Subject: Gundry Solar Farm (SSD-48225958) – Environmental Impact Statement (EIS)

NSW DCCEEW Water Group has reviewed the Environmental Impact Statement and has recommendations regarding water supply, works on waterfront land and sewage management. Please see **Attachment A** for more detail.

Detailed advice to DPHI Planning & Assessment regarding the Gundry Solar Farm (SSD-48225958) - EIS

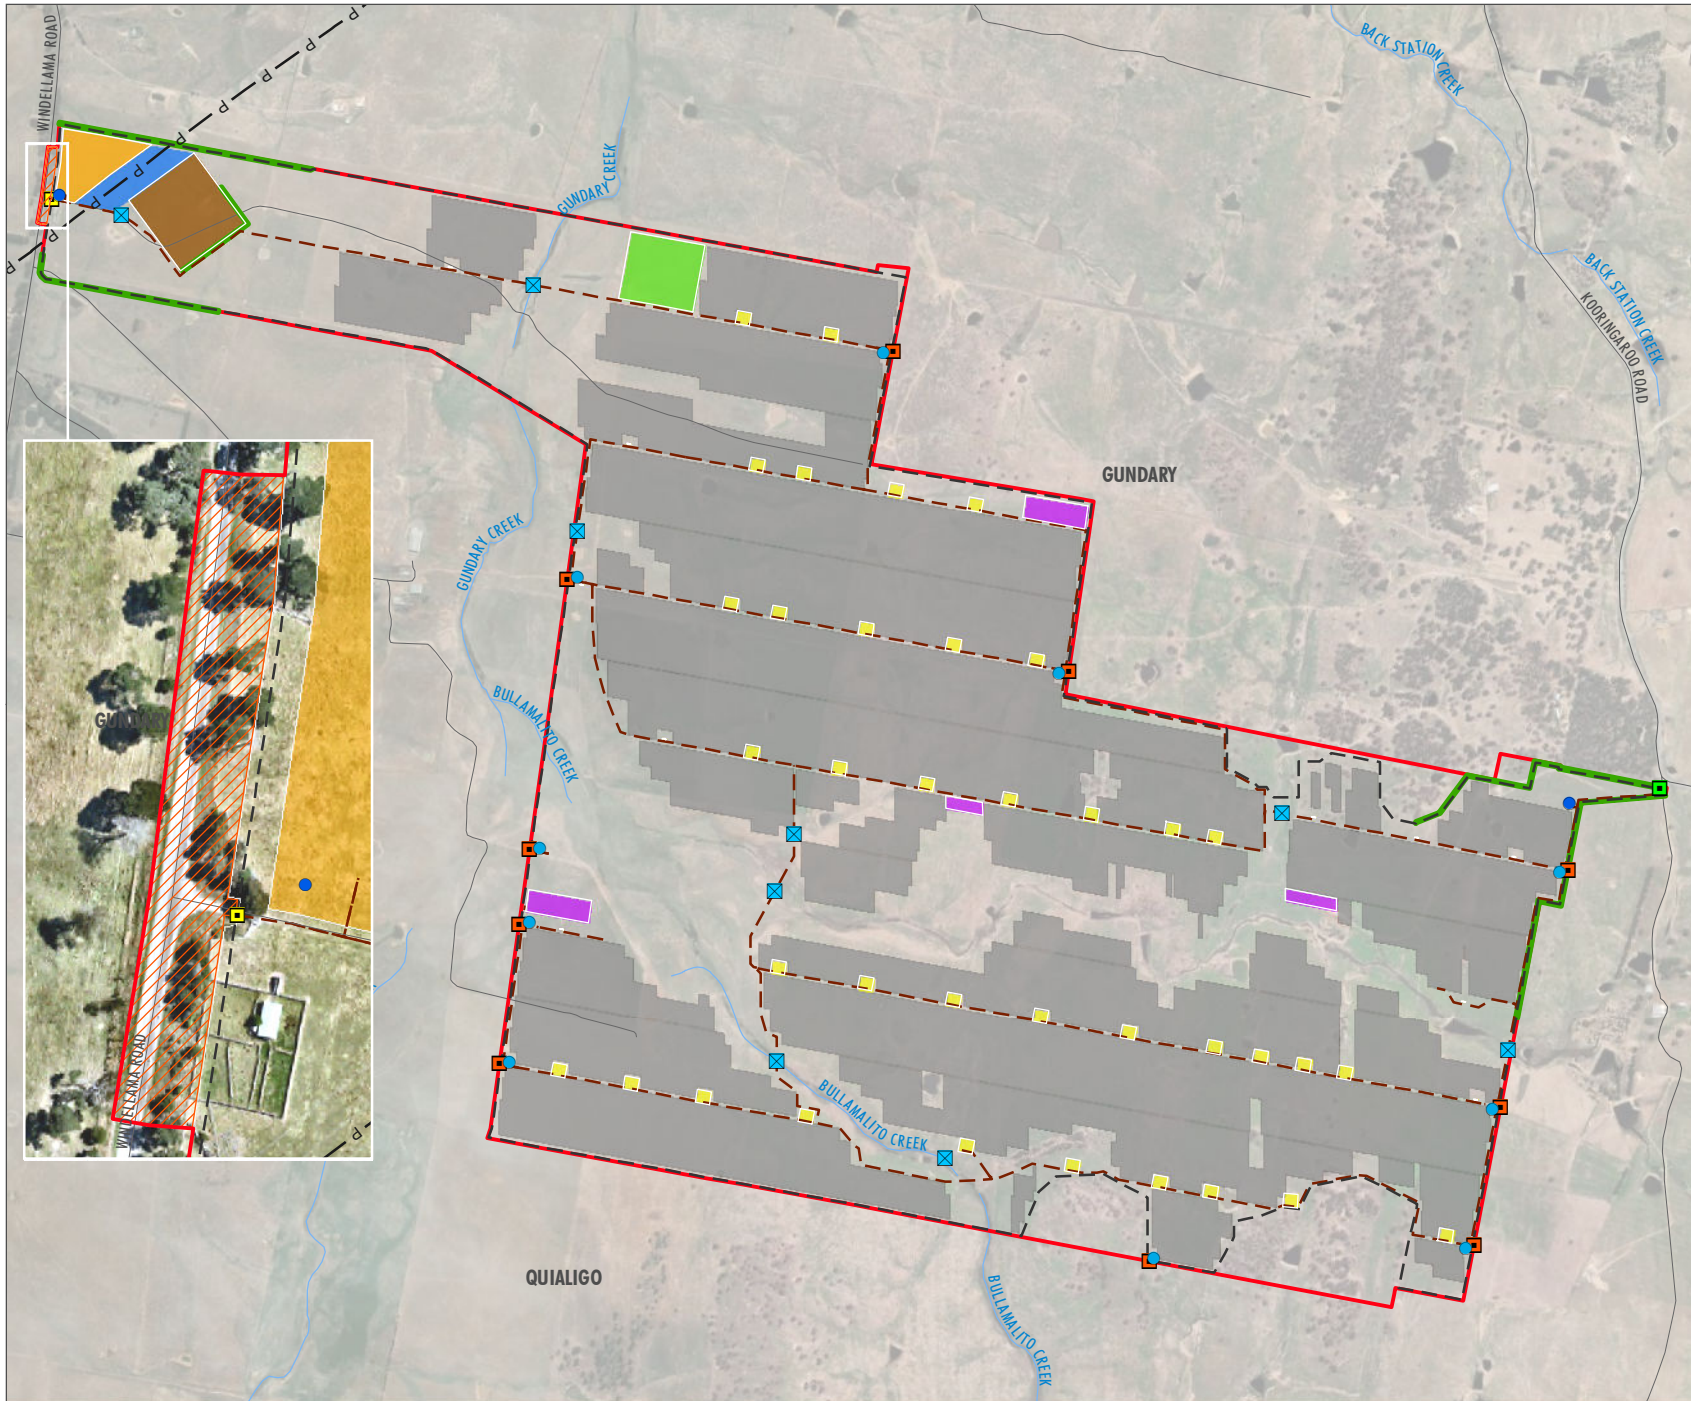
Department of Planning, Housing and Infrastructure request the proponent to clarify the proposed infrastructure layout meets the buffer requirements from watercourses as defined in the Guidelines for Controlled Activities on Waterfront Land (DPE 2022).

The site generally provides buffer zones along the 3rd order and above watercourses except in the western section of the site where there appears to be a construction compound and substation proposed. This will be over a mapped third order watercourse. the Guidelines for Controlled Activities on Waterfront Land can be found here:
